8<sup>th</sup> July 2025

**Steeple Renewables Project - Planning Act 2008 section 51** Further to your letter dated 11<sup>th</sup> June 2025 providing advice following the decision of the Secretary of State to accept the application for examination (the “S51 Advice”), this letter, along with enclosure provides the responses of Steeple Solar Farm Ltd (the “Applicant”).

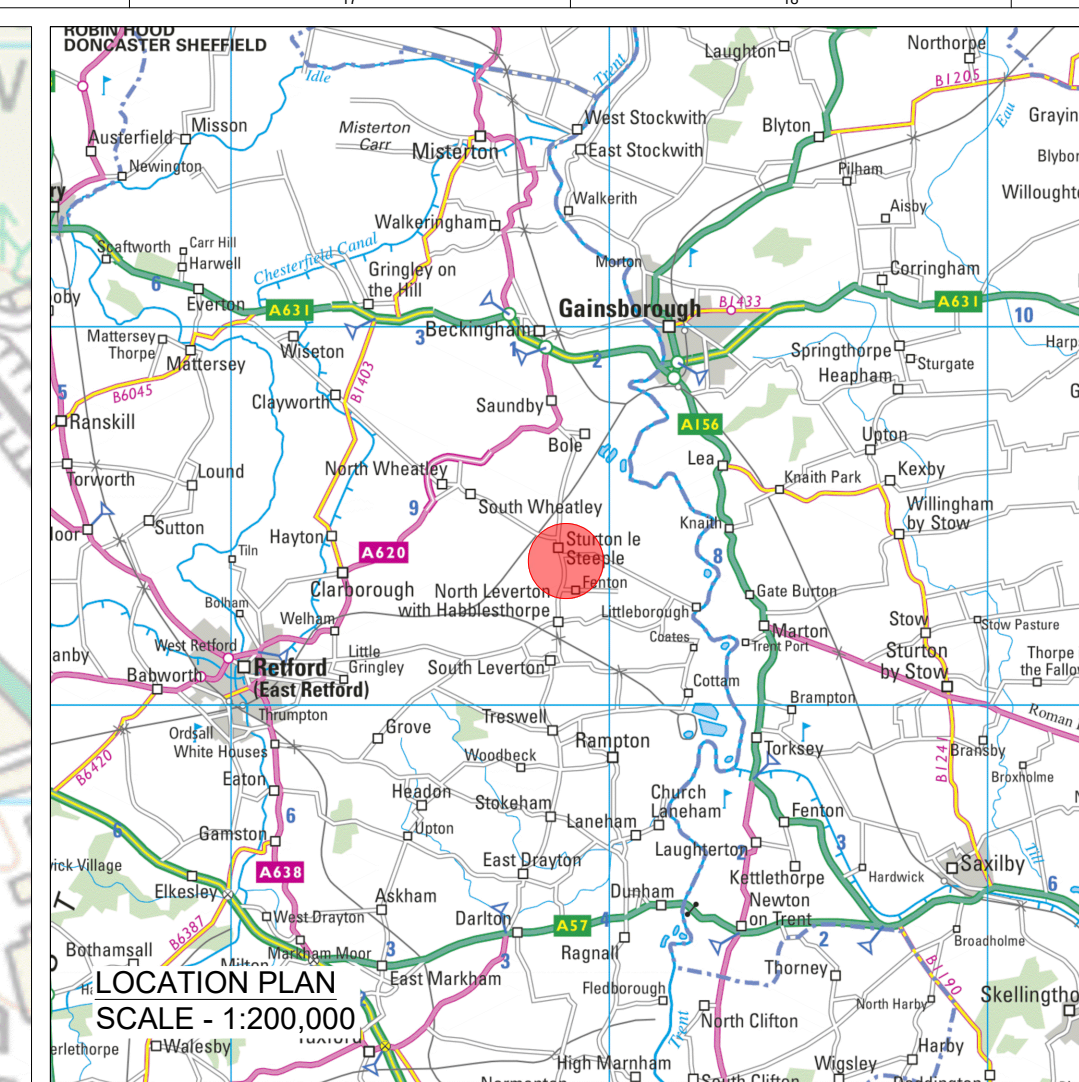
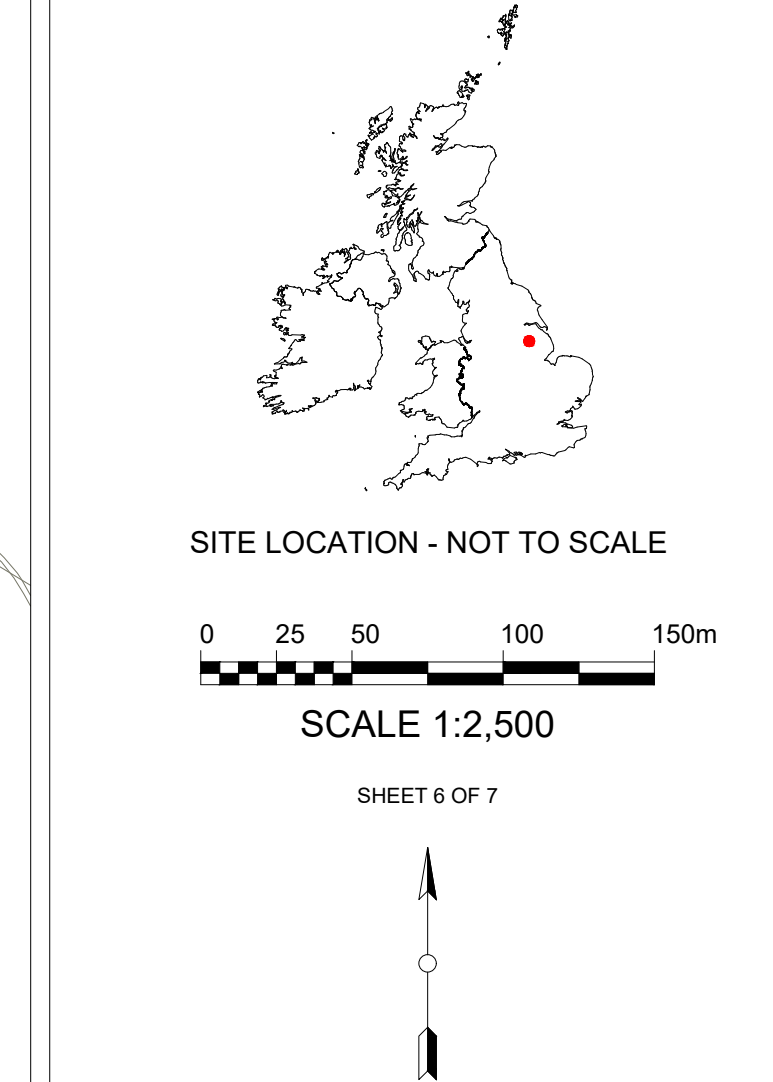
**Order Limits (Doc 2.4).**

The Applicant confirms that cut lines are to be provided for clarity.

OVERVIEW
SHEET 1 OF 7

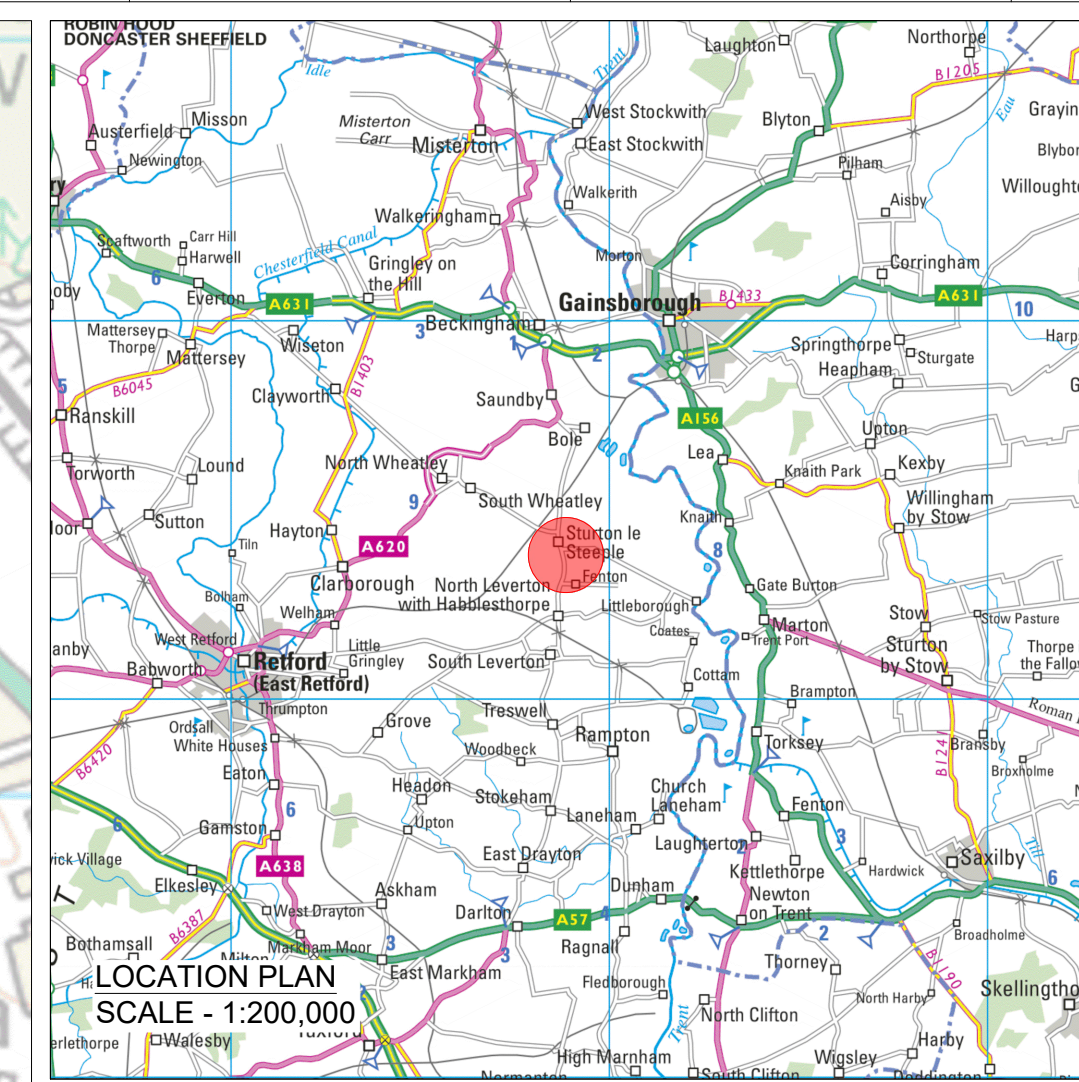
- Figure 1.1 - Site Location Plan (Doc 6.4.1)
- Figure 2.1 - Indicative Site Layout (Doc 6.4.2)
- Figure 3.2 - Topographical Survey (Doc 6.4.3)
- Figure 17.2 - Utilities Plan (Doc 6.4.17)
- Plans of Statutory /Non-Statutory Nature Conservation (Doc 2.29)
- Important Hedgerow (Doc 2.34)

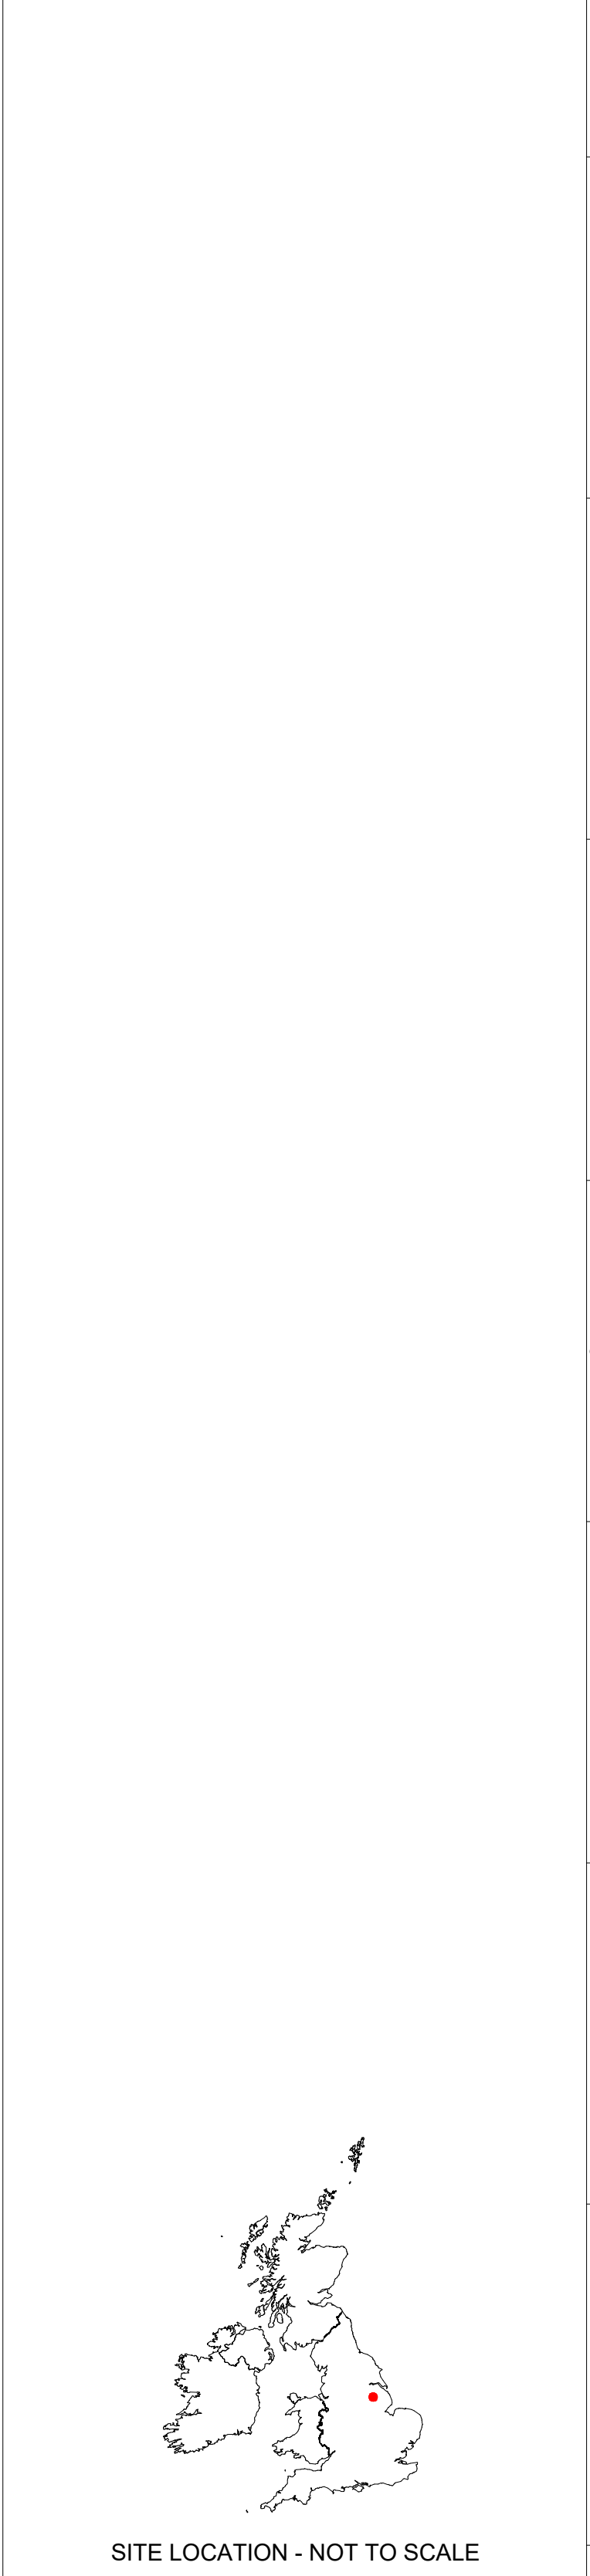
**Cable Crossing Plan (2.35).**

The Applicant confirms that cut lines are to be provided for clarity.
